Preferred Project Report

North West Precinct Redevelopment (MP10_0166)

Royal Prince Alfred Hospital

Submitted to the Department of Planning and Infrastructure
On Behalf of Health Infrastructure

DEPARTMENT OF PLANNING SUBMISSION
PHOTOMONTAGE PERSPECTIVE - SHEET 2
ROYAL PRINCE ALFRED HOSPITAL
North West Precinct Project, Camperdown

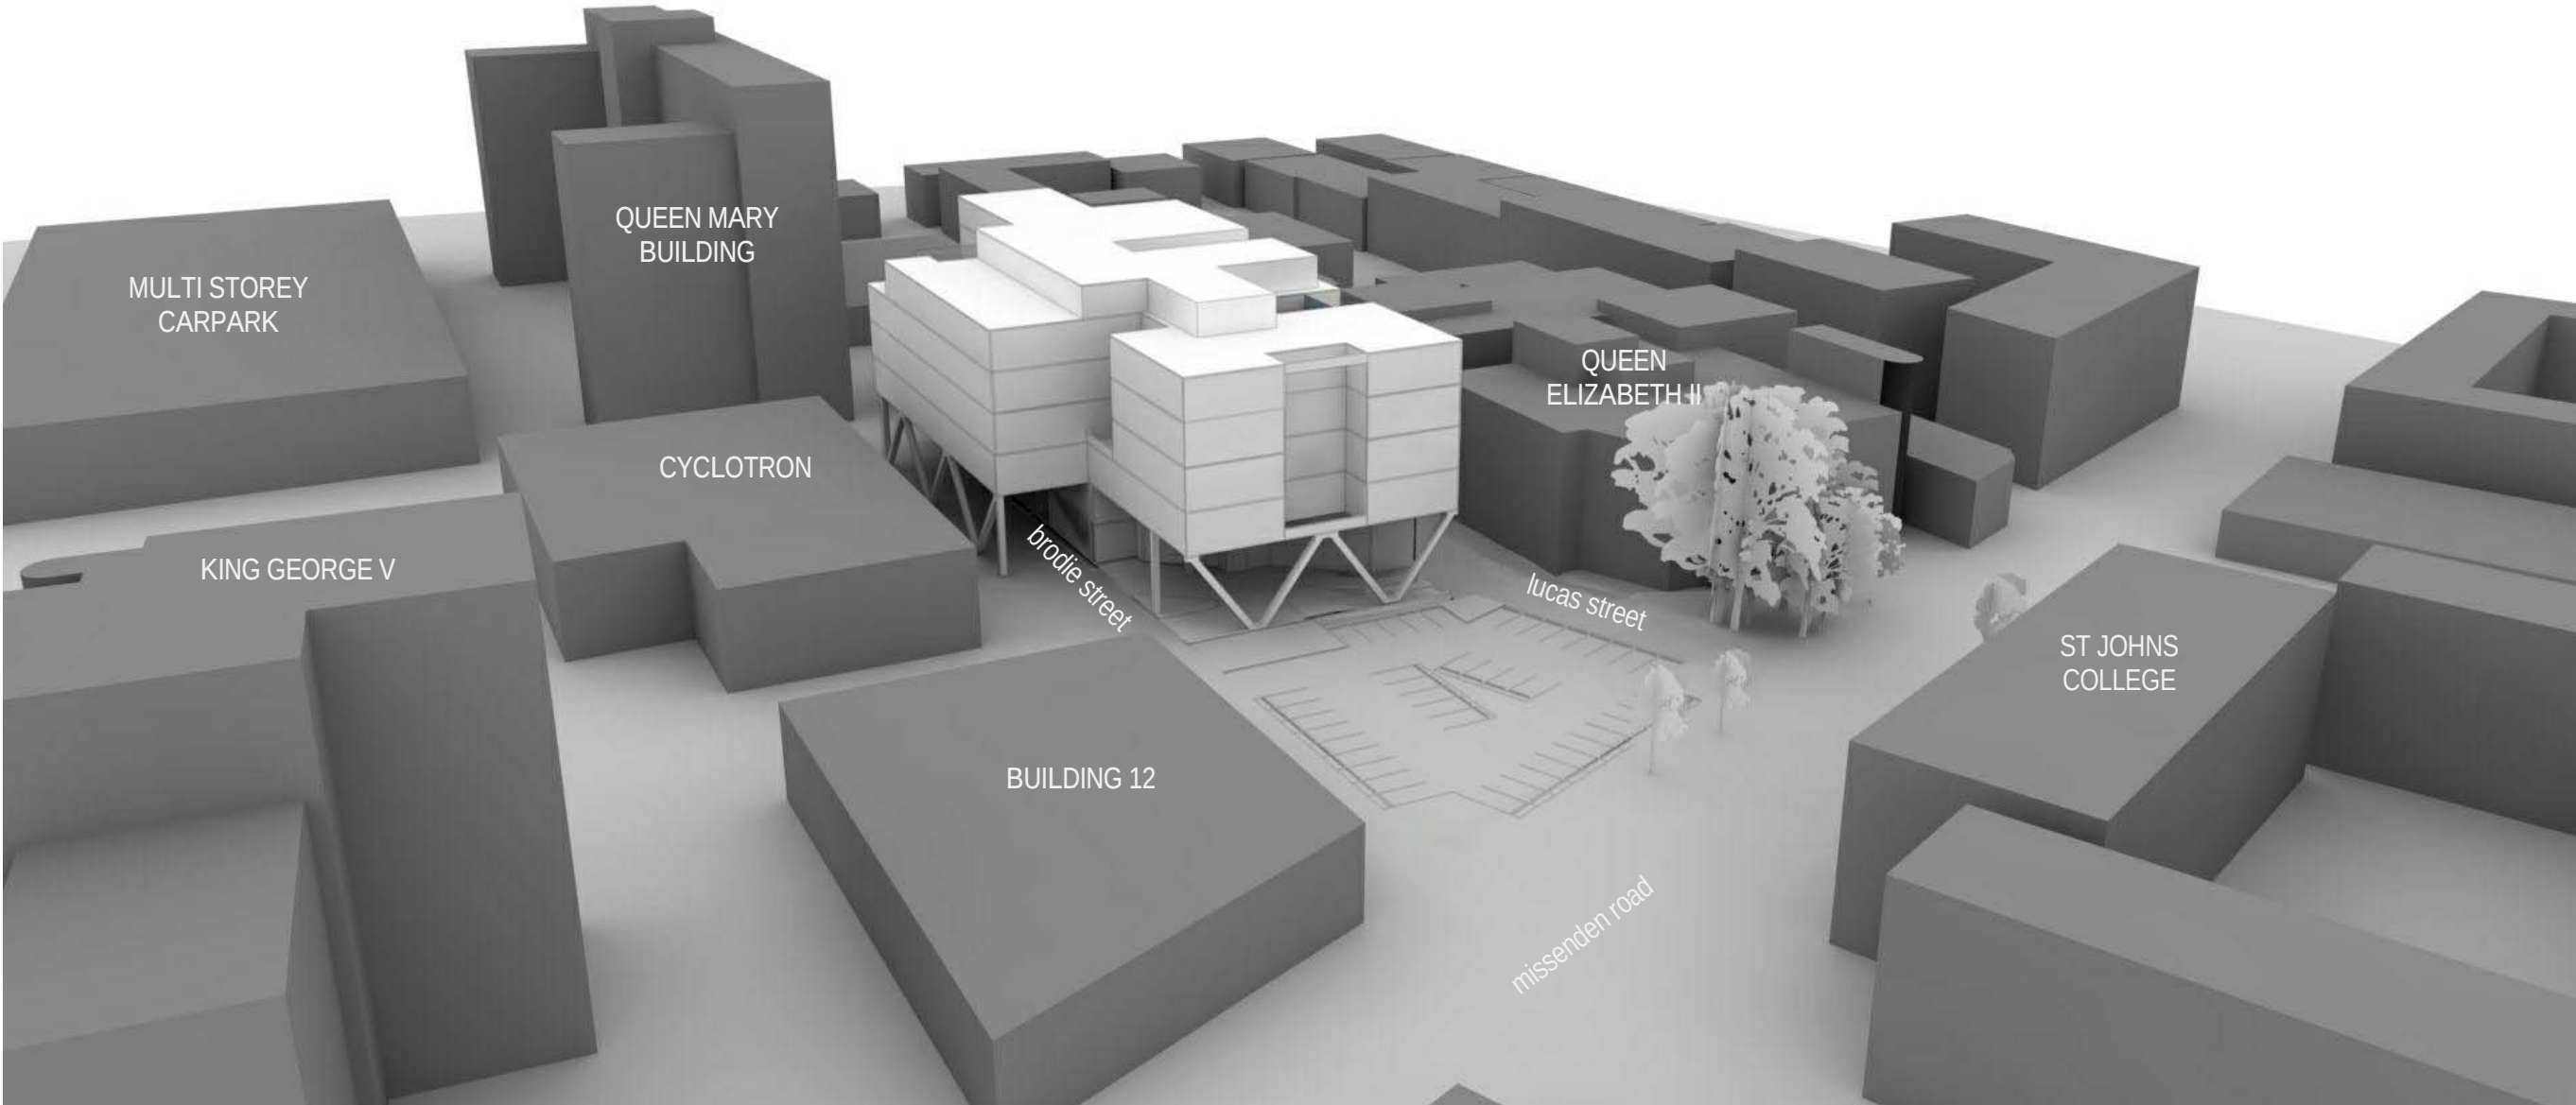
As illustrated within the revised photomontage at **Figure 1**, there is greatly improved activation and transparency provided to Lucas Street that filters up the building (particularly at the eastern end).

GROUND LEVEL PLAN

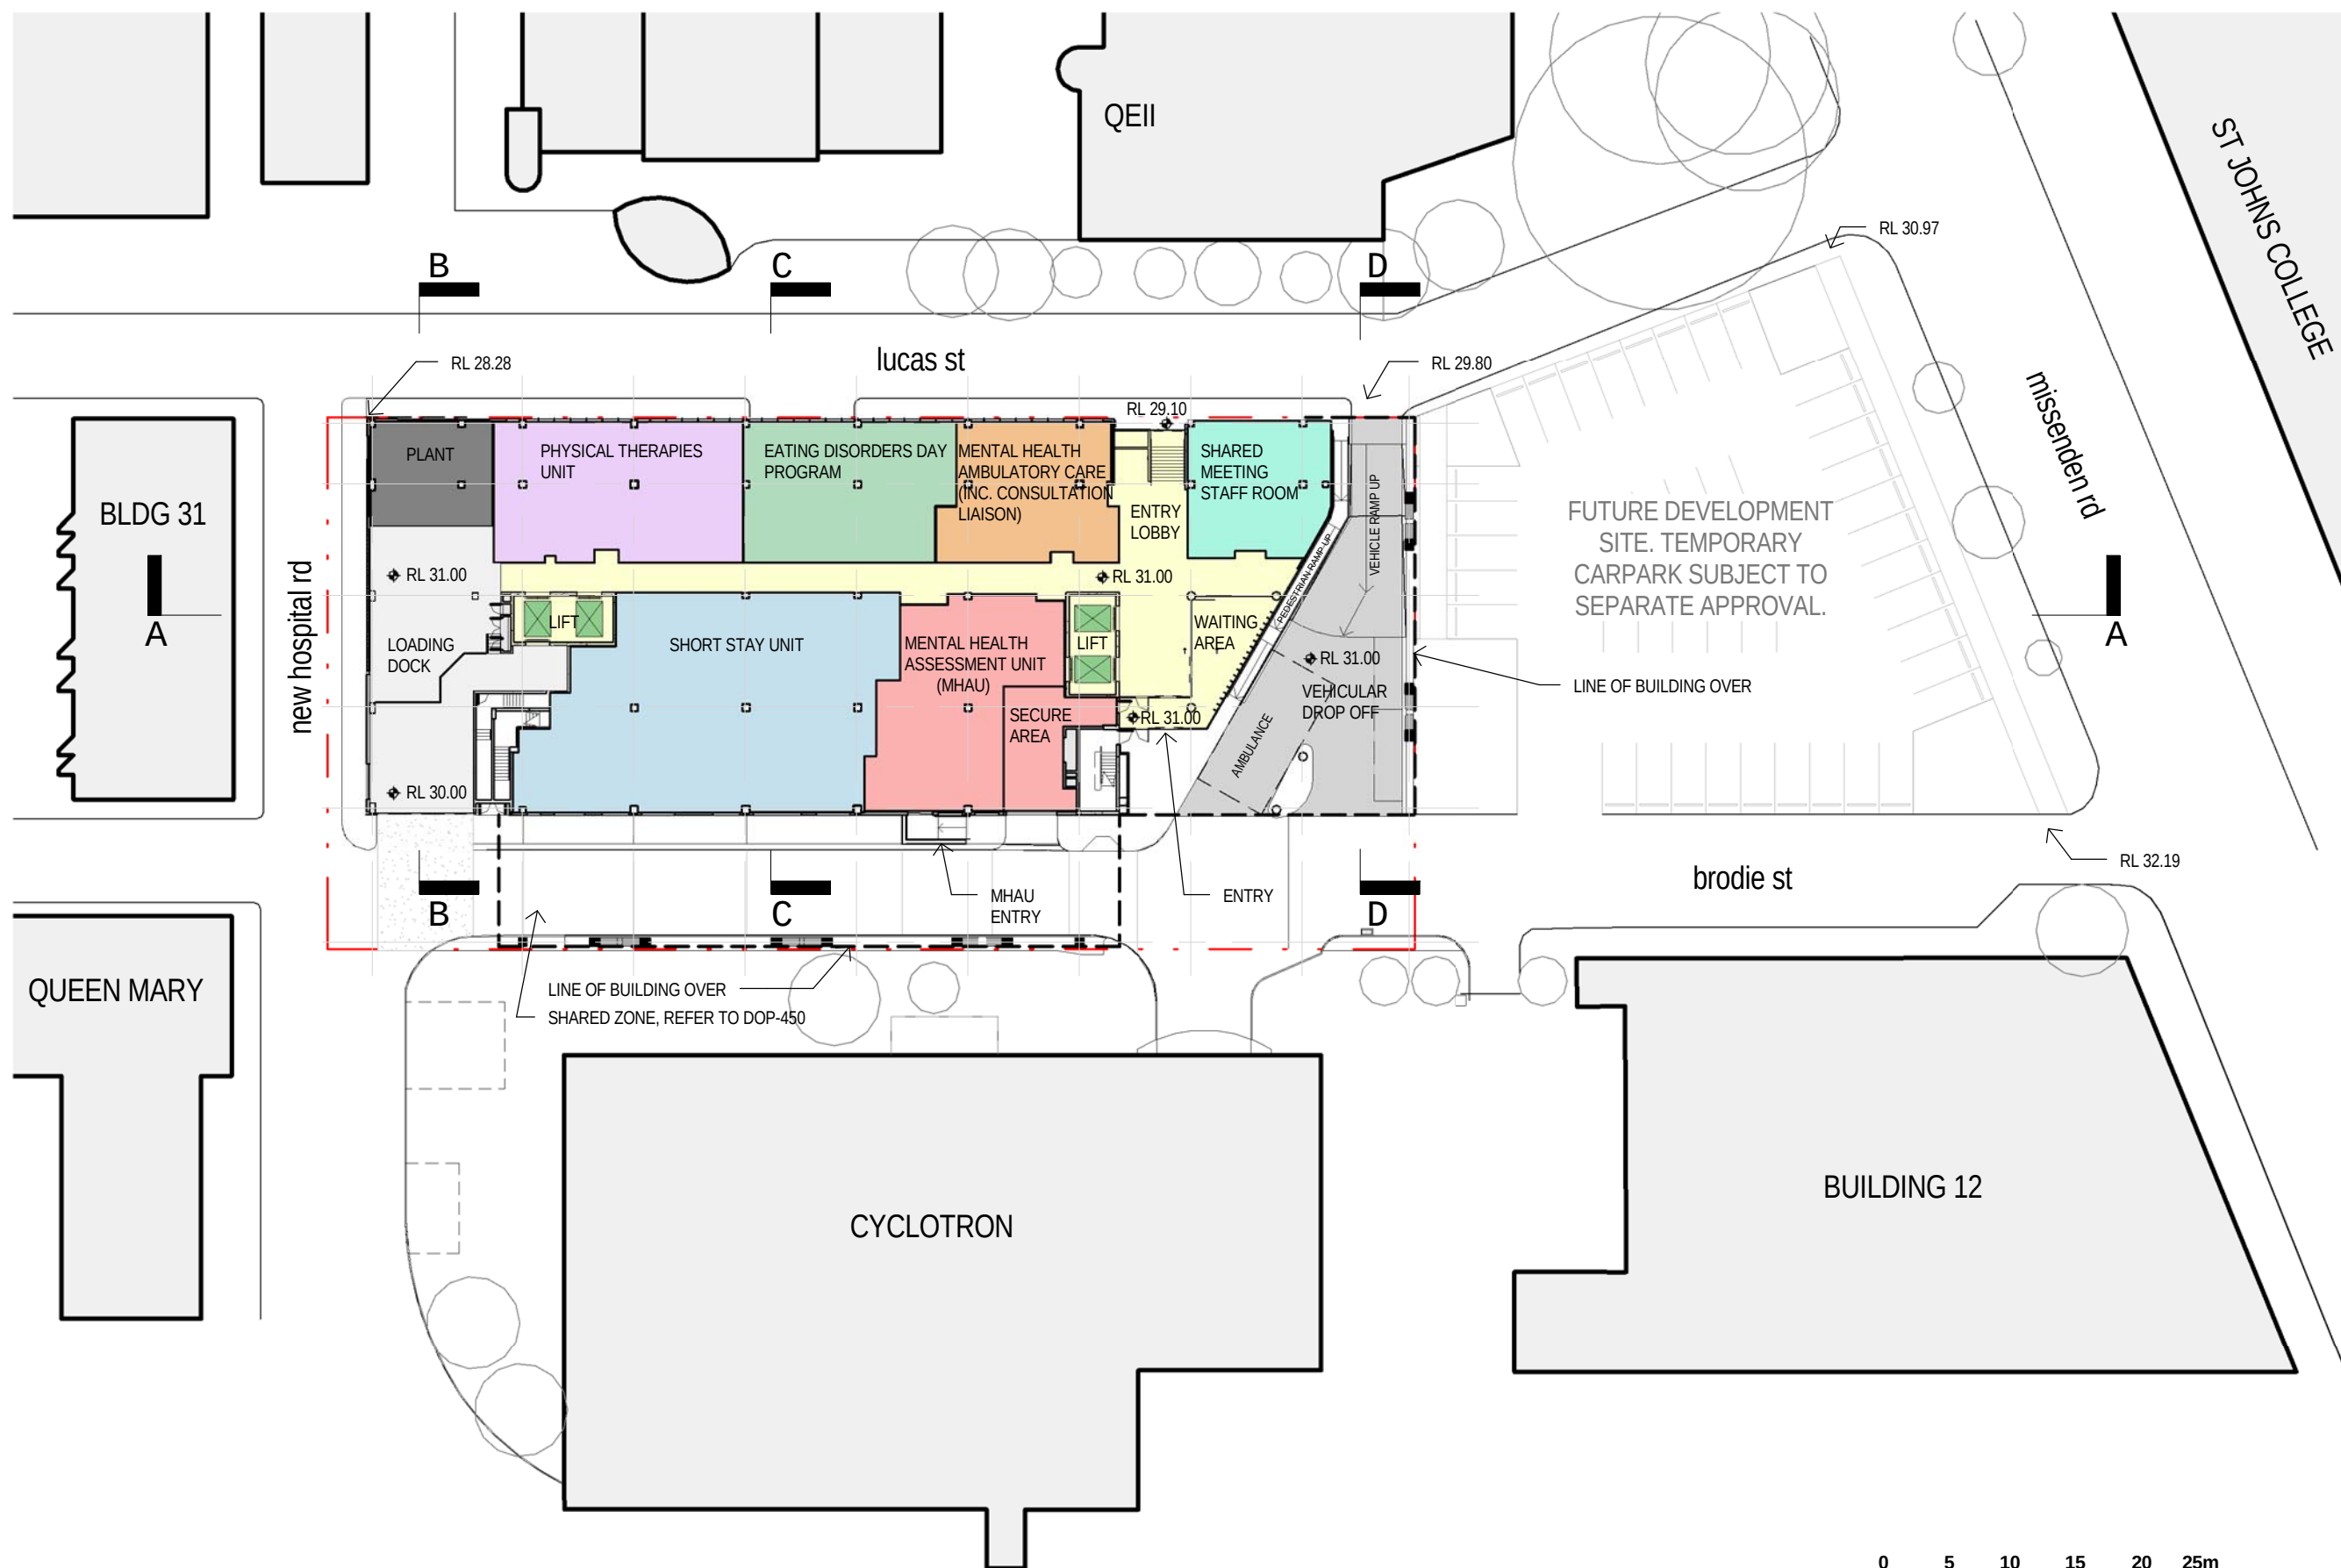
Of particular note the design now incorporates a secondary access point that fronts Lucas Street (refer to the revised Architectural Plans included at **Attachment 2** for further details). The main access point has also been repositioned so that it has a closer relationship to Brodie Street, providing increased activation along this private road frontage.

SOUTH ELEVATION
1 : 500

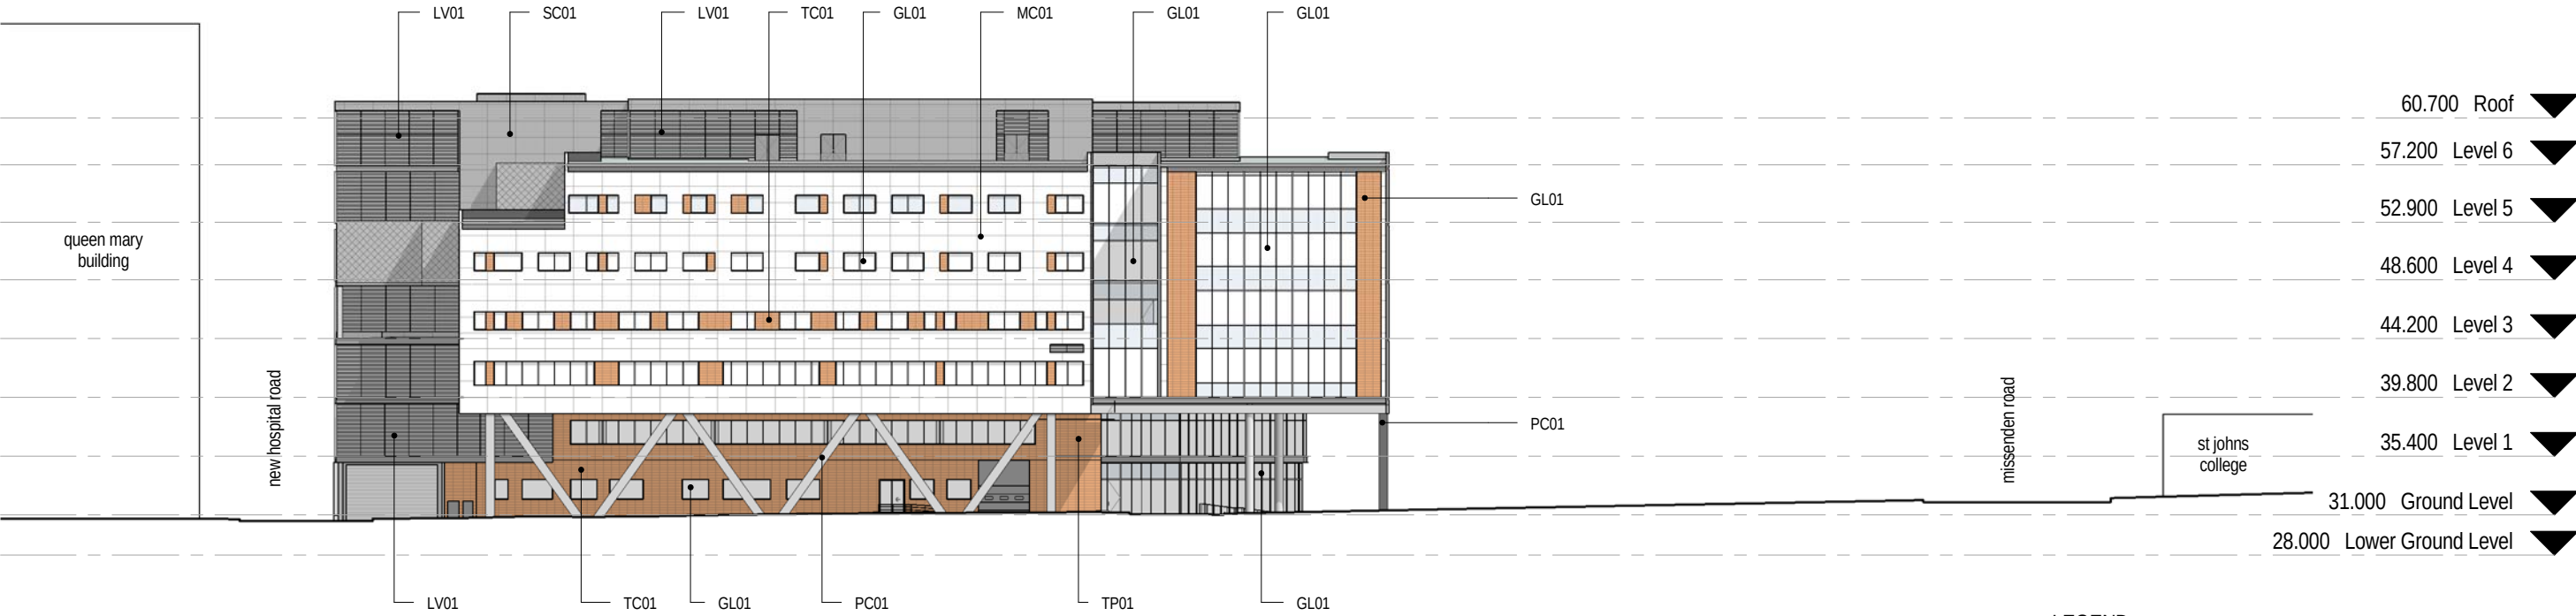
A revision to the Lucas Street frontage façade design and materials provides a more interesting presentation and improves the relationship of solid to void (refer to **Figure 2**).
